From: Zac Denton
Sent: 19 August 2019 09:27
To: Planning Scanning
Subject: FW: AB/71/19/L - 52 Tarrant Street, Arundel, BN18 9DN

From: Estella Wood [REDACTED]
Sent: 16 August 2019 14:01
To: Zac Denton [REDACTED]
Cc: Andrew Fuller [REDACTED]
Subject: AB/71/19/L - 52 Tarrant Street, Arundel, BN18 9DN

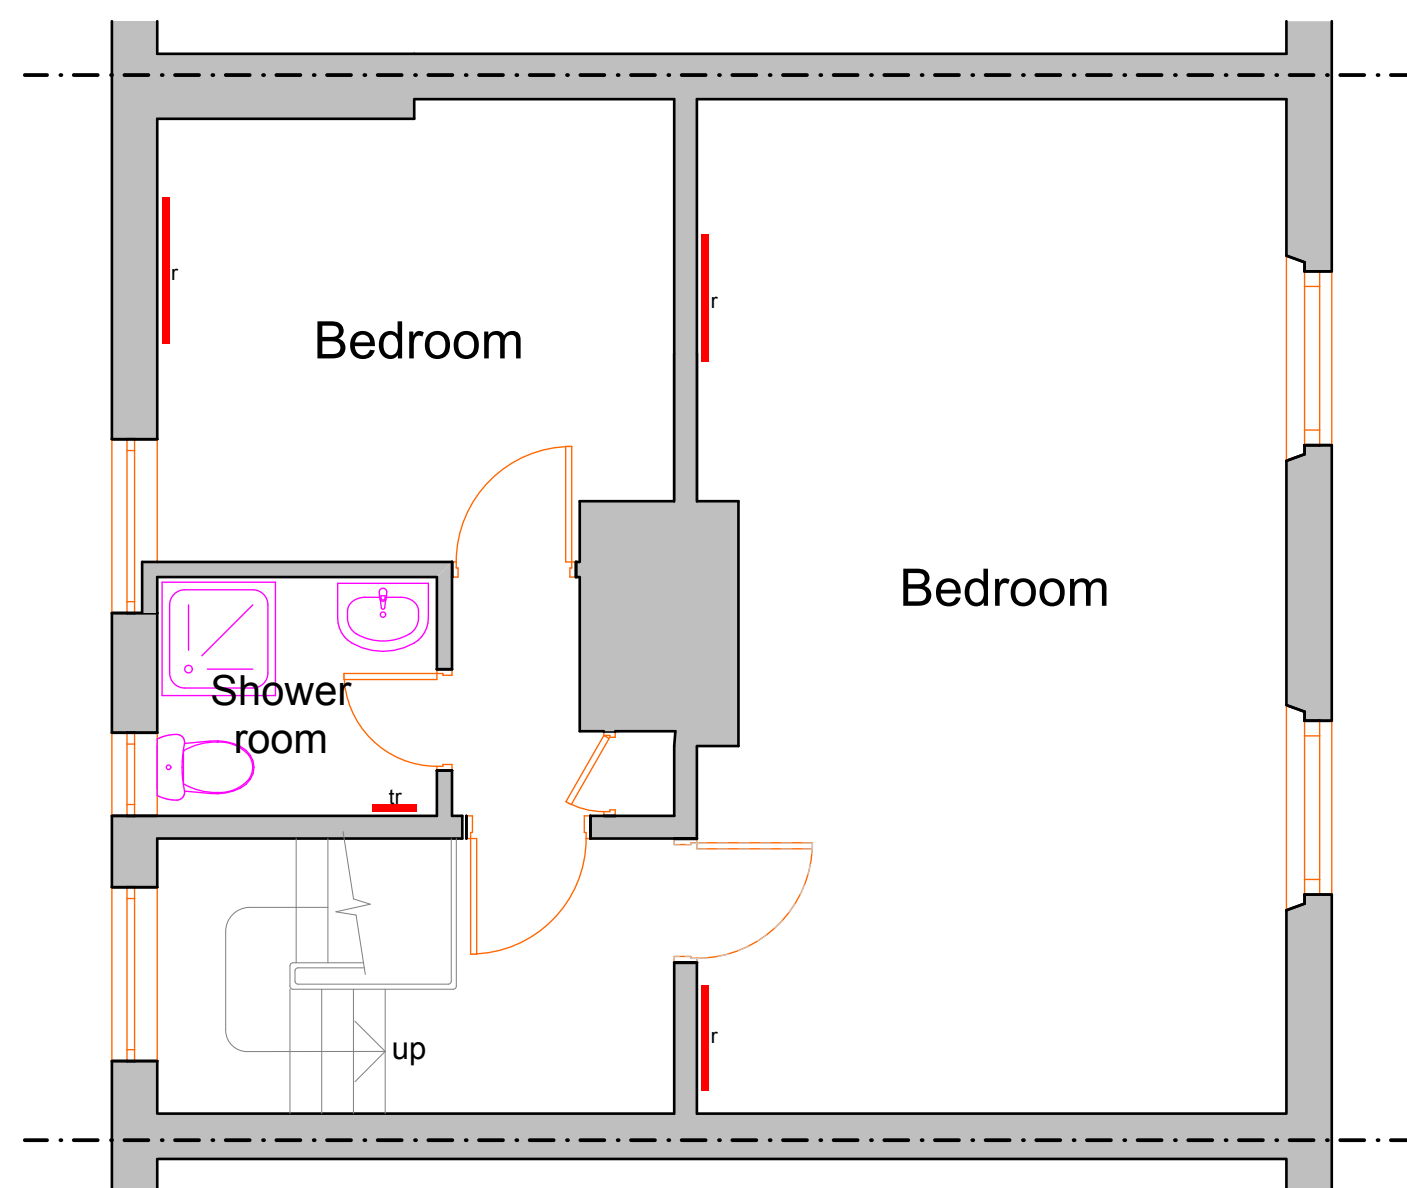
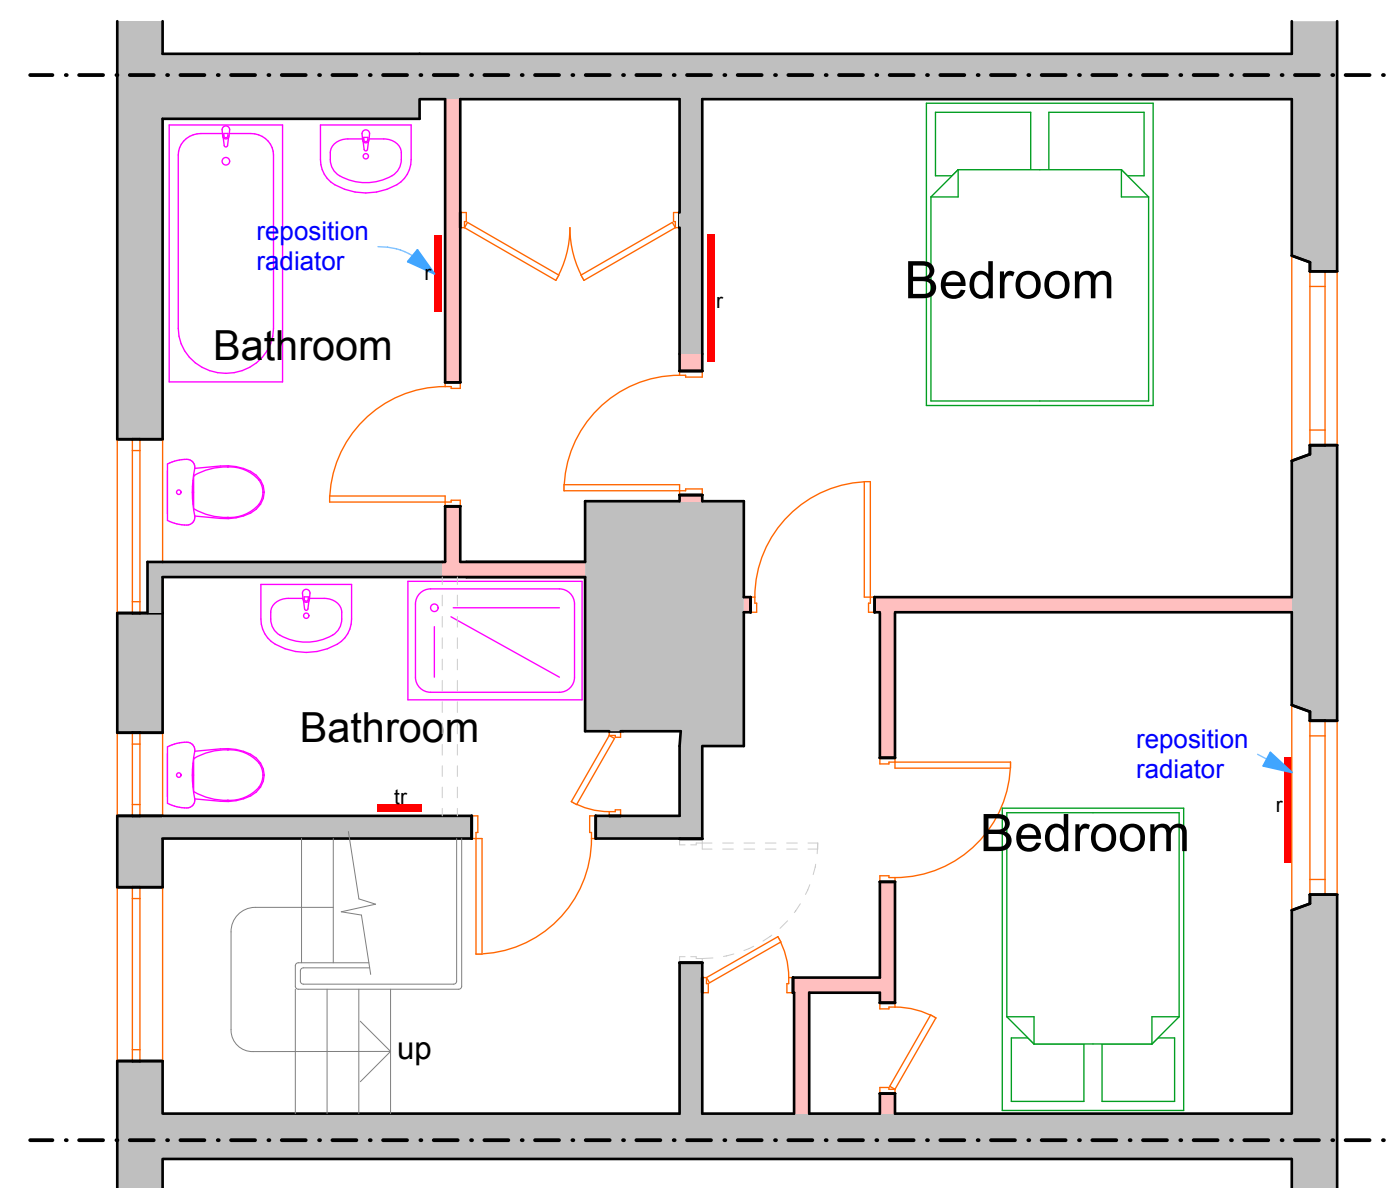
With reference to Martyn White's comments regarding the re-use of the internal door, I can confirm this will be re-used within the proposed alterations.

I can also confirm that the materials for the architraves, skirtings and joinery will match the existing.
